# KITTITAS COUNTY

### MEMORANDUM

TO: Jeff Watson, CDS  
FROM: Kelly Bacon, Engineer Technician I *KB*  
DATE: July 11, 2016  
SUBJECT: Chimpanzee CU-15-00007

SITE PLAN

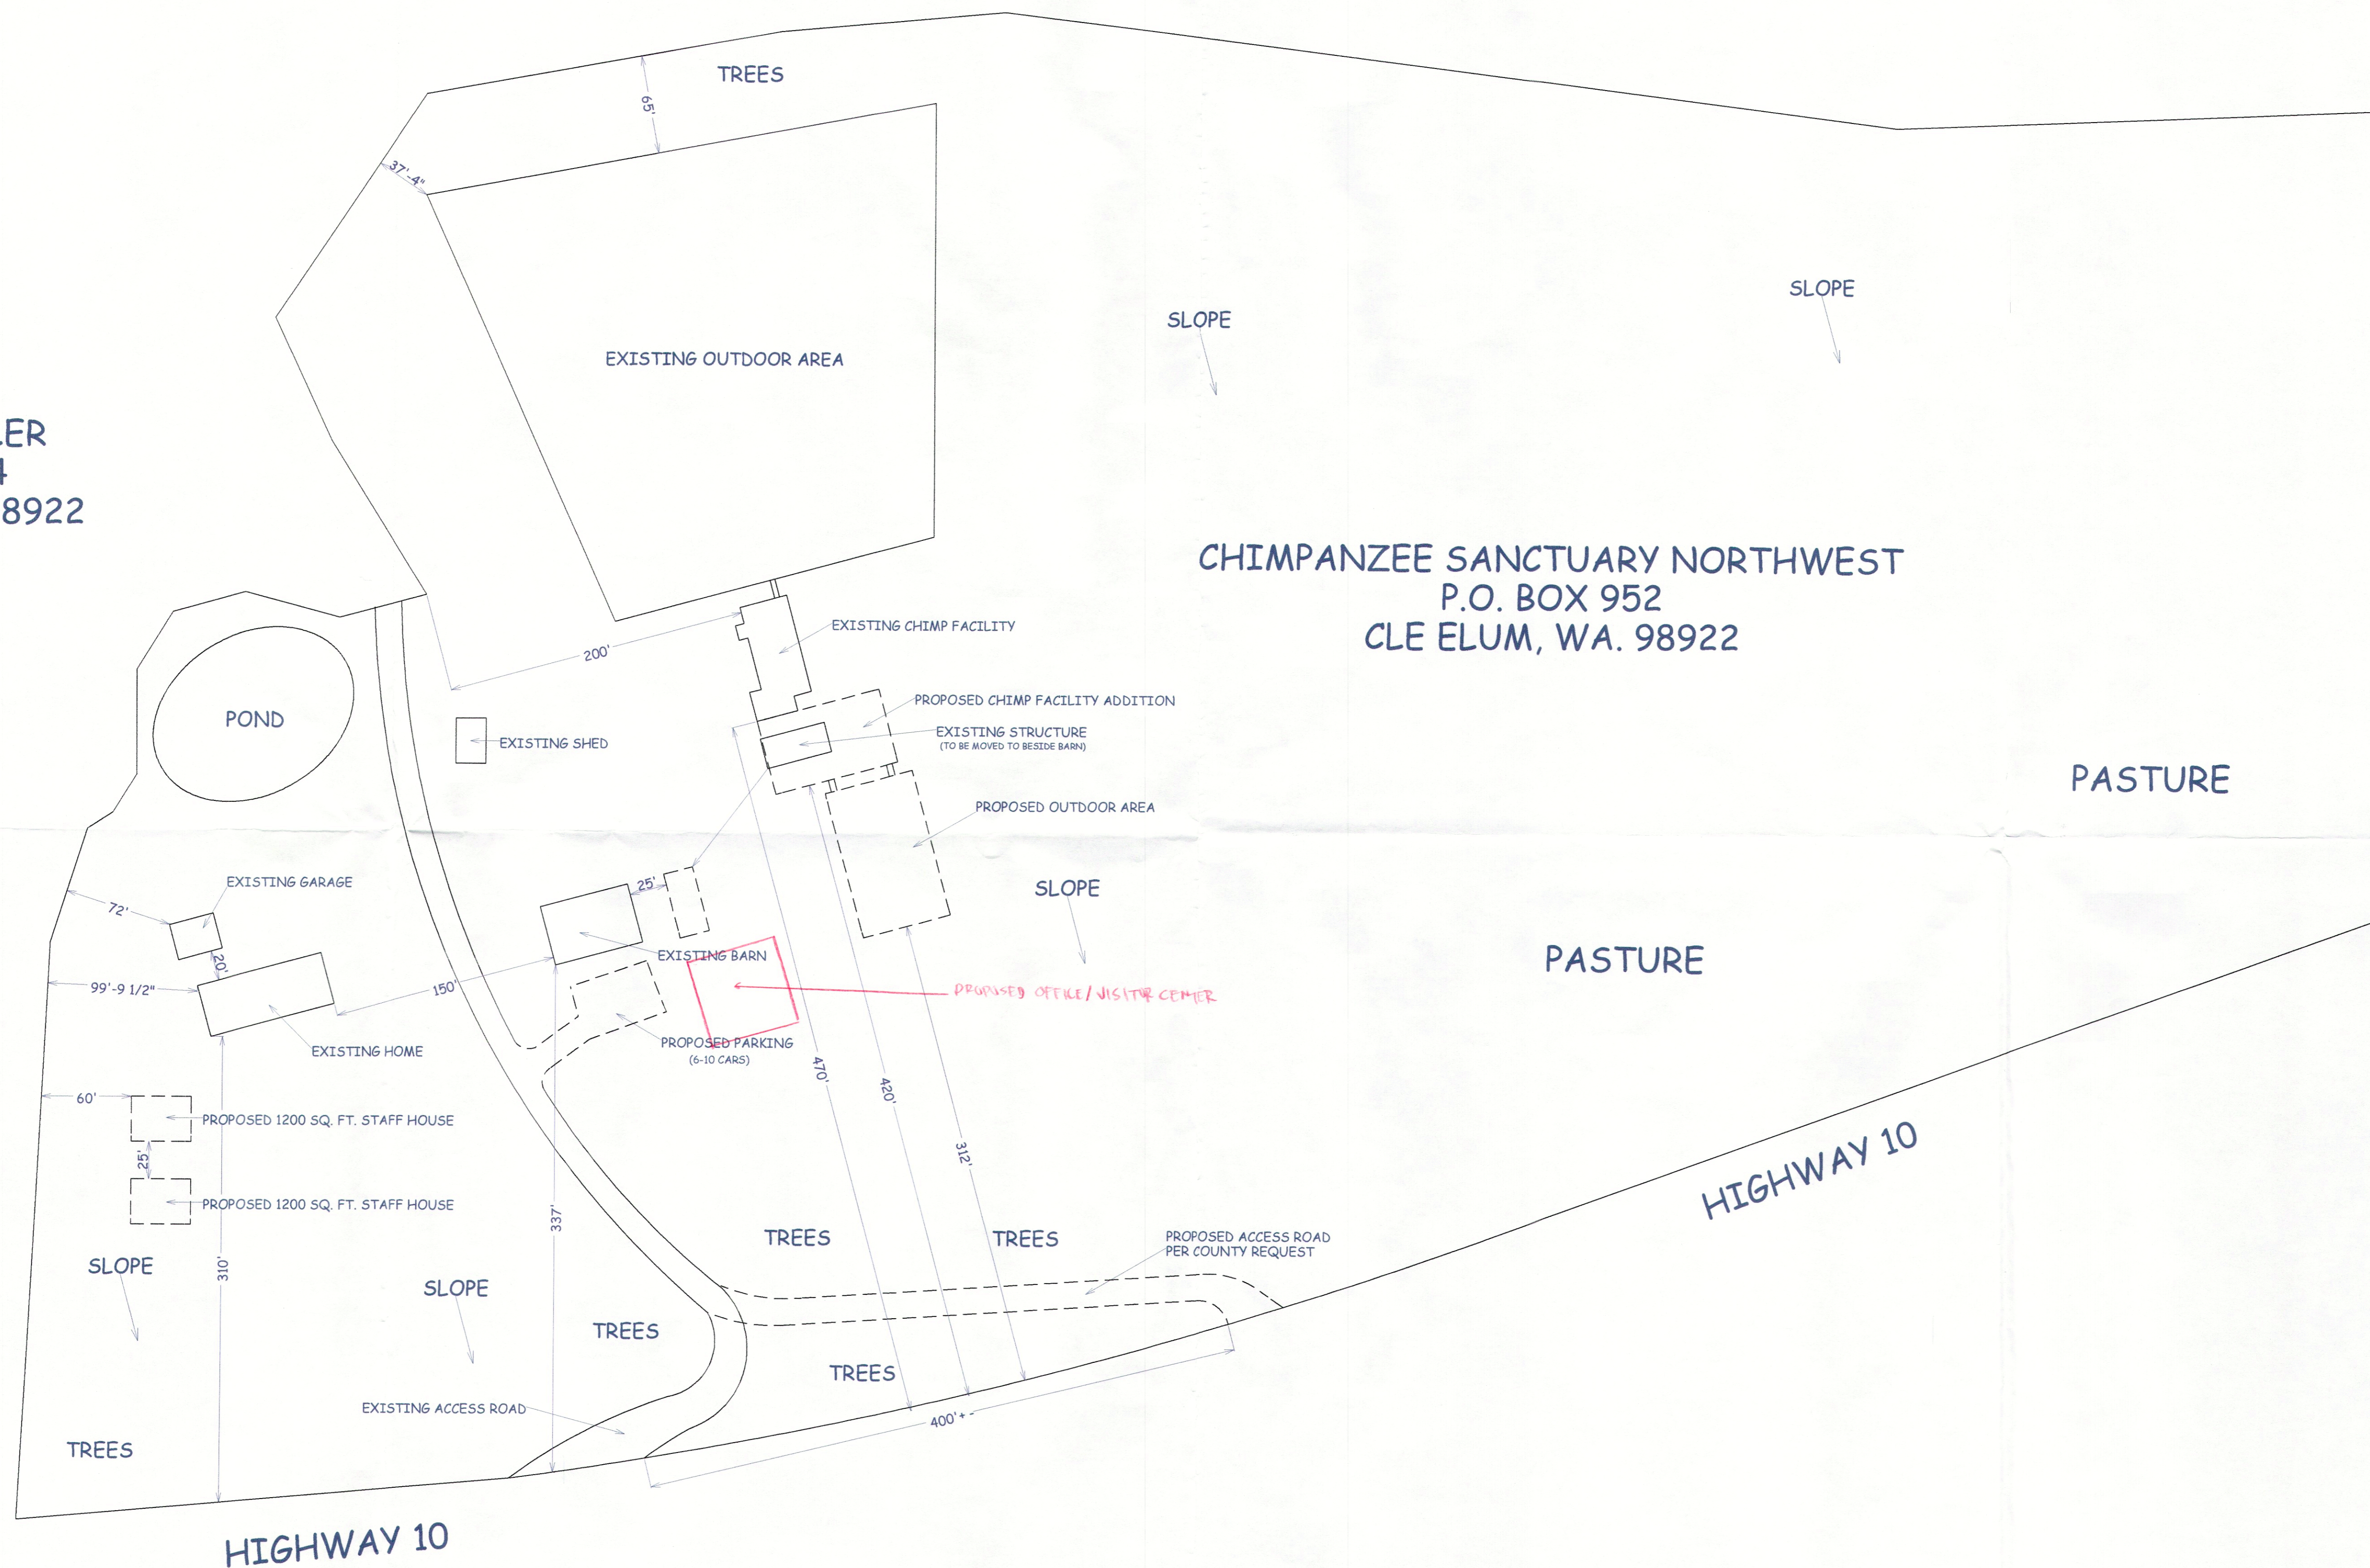
- A. Transportation Concurrency: A Transportation Concurrency application is required for the new proposal.
- B. Site Access: Access to the Chimpanzee Sanctuary is located off of Hwy 10 a State Route. Applicant will need to comply with all Washington State Department of Transportation requirements.
- C. Storm Water Plan: A storm water plan prepared in accordance with the Eastern Washington Storm Water Management Manual by a licensed engineer in the State of Washington is required.
